Application number: 2025/92331	
What is the application for?:	Variation of conditions 2 (plans), 3 (use of floors) and 4 (operating hours) of
Address of the site or building:	Almondbury Working Mens Club, Southfield Road, Almondbury, Huddersfield, HD5 8RY
Postcode:	HD5 8RY

Proposed Rear Elevation

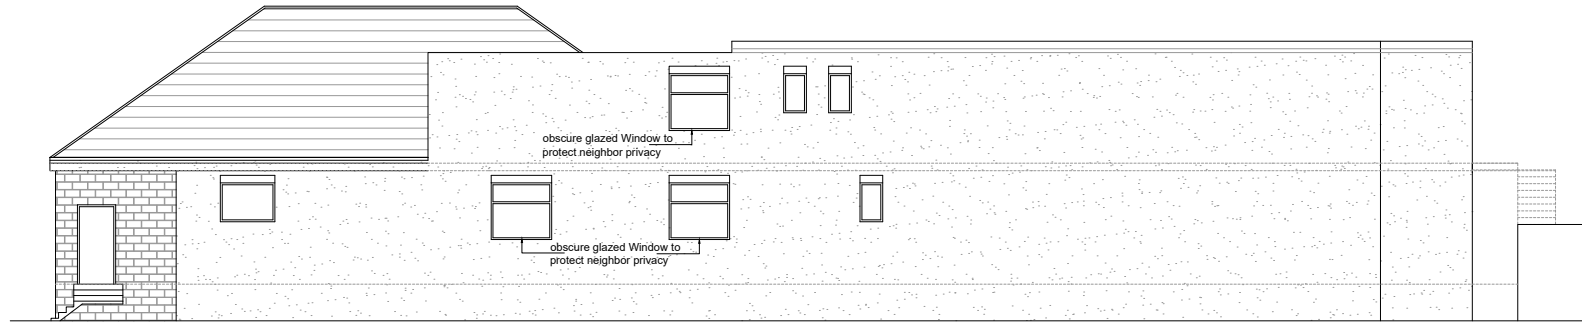
I am writing to formally object to the proposed installation of frosted windows at the the back of the building.

While frosted glass may be intended to reduce overlooking, the reality is that these windows will directly face our living rooms. The back of the building is extremely close to our homes, and the new windows will look straight into our primary living spaces. This raises serious concerns about loss of privacy and visual intrusion.....We would also appreciate clarification on whether the proposed back windows will be fixed or capable of being opened. Given their close proximity to our homes, the ability to open these windows could further increase noise, disturbance, and loss of privacy, due to the cafe and the room area which could be used by the nursery children.

We respectfully request that Kirklees Council conduct a site visit to assess the actual distance between the building and our homes. The proximity is such that any new windows—especially those requiring the wall to be knocked through—will have a direct and disruptive impact on our privacy, comfort, and daily life. A formal inspection would help clarify the extent of this impact and ensure that planning decisions are made with full awareness of the surrounding residential context.

In addition, we have observed that a door has been added to the rear of the building, leading out onto a flat roof area. To our knowledge, this door was not included in the original planning application and appears to be an unauthorised addition. We are concerned about the potential use of this roof space and the further impact it may have on neighbouring residents in terms of privacy, safety, and noise. We ask that Kirklees Council investigate this alteration as part of their site assessment.
